Development Application and Planning Proposal Review NSW Planning Portal Concurrence and Referral

Authority	Authority's Reference	Agency Concurrence and Referral	Authority Contact	Authority Notification	Submission Due	Submission Made
NSW Dept. of Planning, Housing & Infrastructure	SSD-74509208		Camille Kunder	21/05/2026	17/06/2026	22/05/2026

Environmental Impact Statement (EIS) for Campbelltown Arts Centre Expansion. Expansion and redesign of the existing Campbelltown Arts Centre.

Proposed demolition of the existing building and site works showing indicative existing substation location

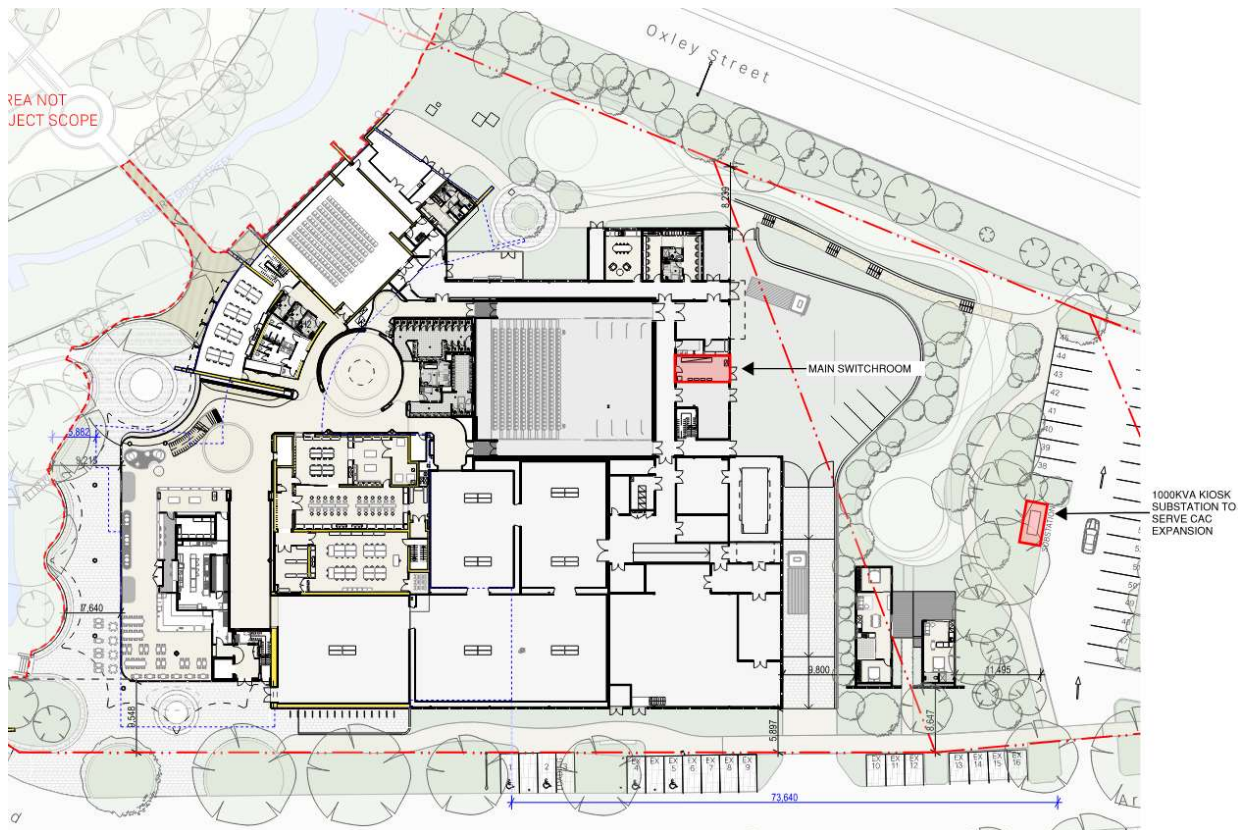
The existing substation S13617 is rated to only 500kVA and is currently loaded to approximately half of this. It does not have sufficient capacity to serve the proposed expansion based on maximum demand assessments to AS 3000 Table C3 and is currently located in the footprint of the proposed construction works. Thus, an application is in progress with the ASP3 accredited service provider and Endeavour Energy (reference number UCL15613) to replace and relocate the existing padmount substation with a new larger 1000kVA padmount substation.
